CITY OF ALBUQUERQUE

November 4, 2013

**Re: Lot 11, Blue Sky Business Park, Grading and Drainage Plan
Engineer's Stamp dated 10-03-13 (D16/D002A2)**

**Areas: (acres)**

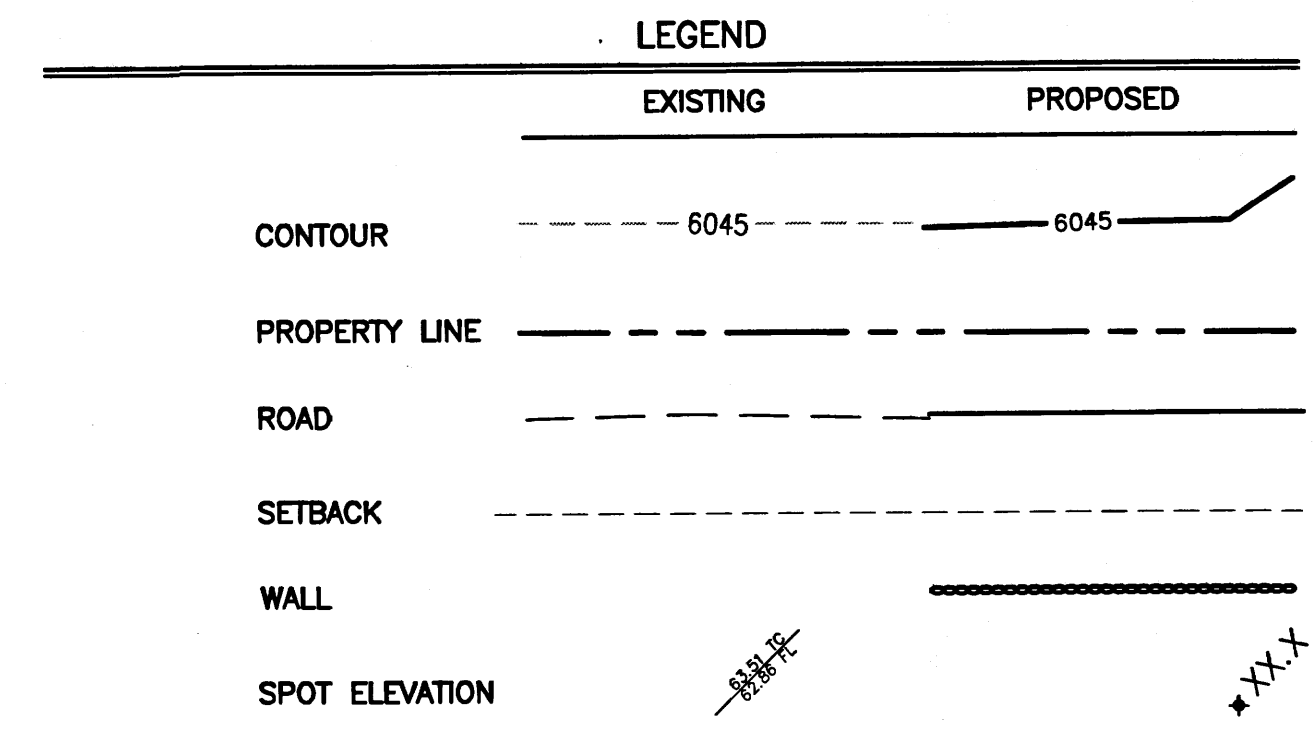
- The entire site has been previously graded. Therefore, Treatment A under existing conditions should be zero. Please refer to City Drainage number D16/D002A for developed conditions.
